Project Name: Moody's Collision Center Parking Expansion
Address: 495 Presumpscot Street
Applicant: Shawn Moody, Real Estate Holdings
Planner: Nell Donaldson

Project ID: 2015-113
CBL: 415-B-009

TO: Nell Donaldson, Planner
FROM: David Senus, PE
DATE: October 1, 2015
RE: Moody's Collision Center, Final Level II Site Plan Application

**DETENTION BASIN WITH UNDERDRAINED GRASS FILTER**  
NOT TO SCALE

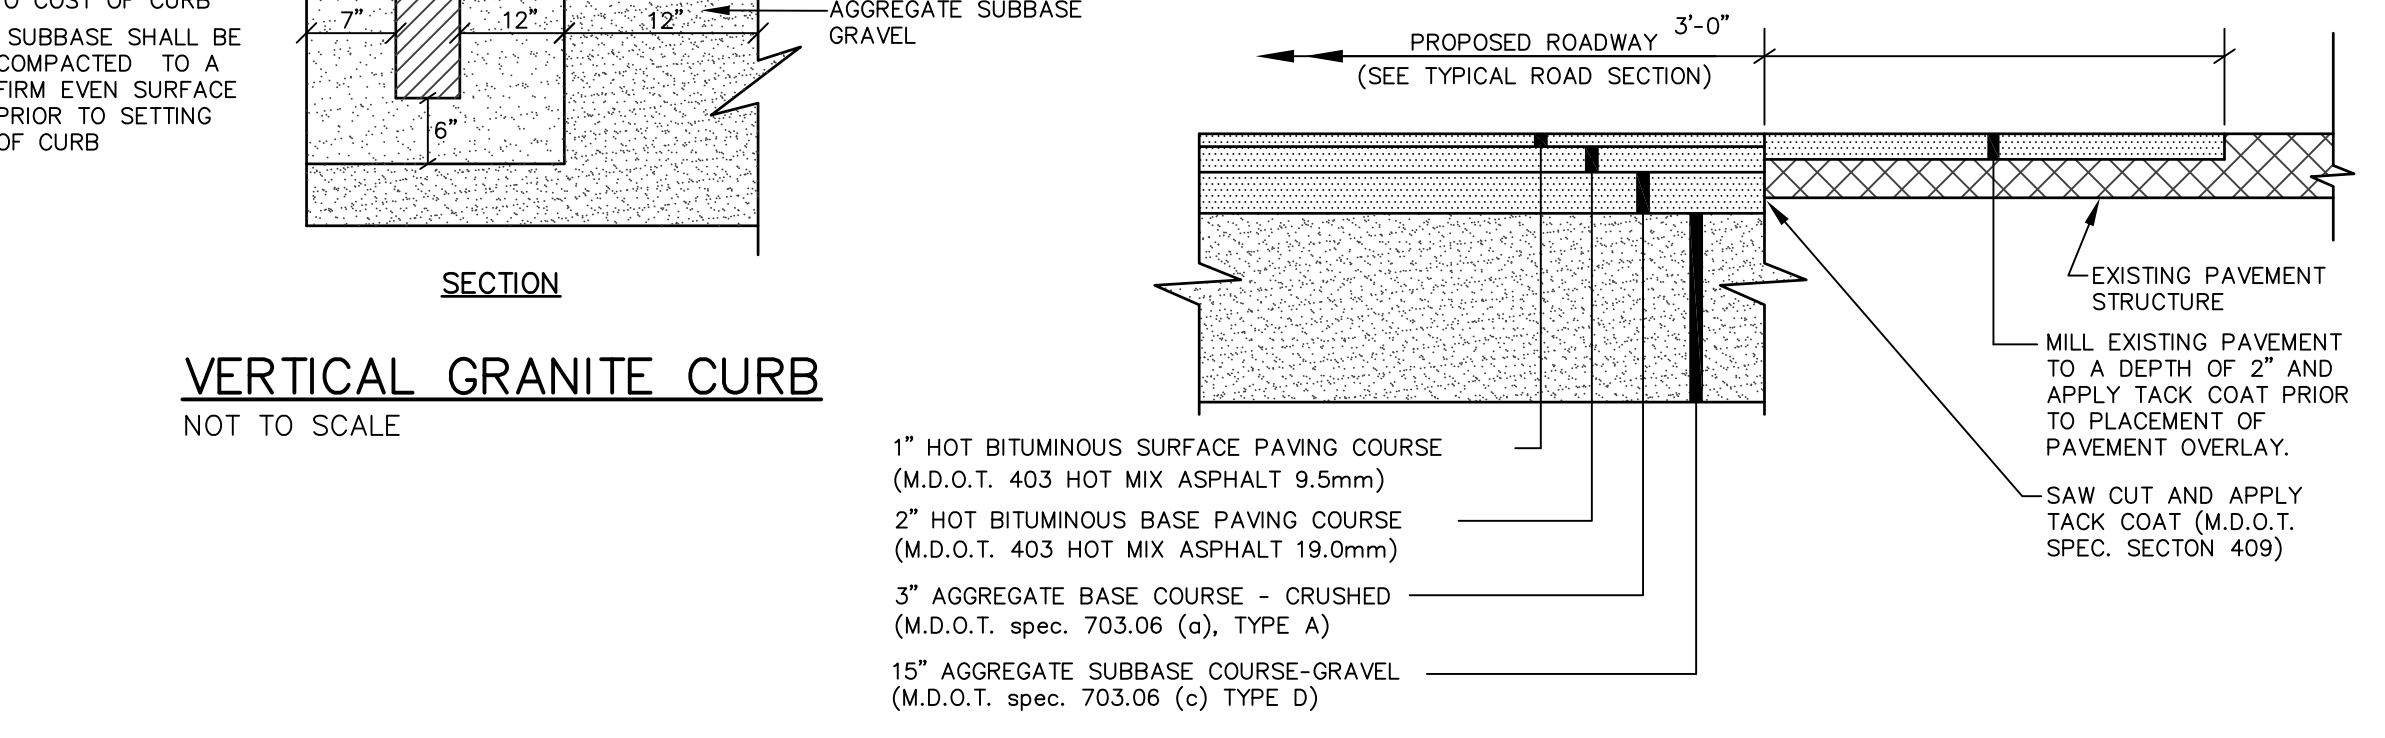
- 2) The plans and details should include a permanently stabilized edge along the parking lot where runoff will flow into the soil filter system. Consideration should be taken to ensure that concentrated runoff does not back-cut under the pavement along this edge.

1. The applicant shall revise the plans and details to include a permanently stabilized edge along the parking lot where runoff will flow into the soil filter system such that concentrated runoff does not back-cut under the pavement for review and approval by the city's consulting civil engineer; and
2. Prior to the issuance of a certificate of occupancy, the applicant shall make a contribution to the City of Portland, deliverable to the Planning Division, in the amount of \$5,800, based on the cost of installing a sidewalk on remainder of the property frontage on Presumpscot Street.
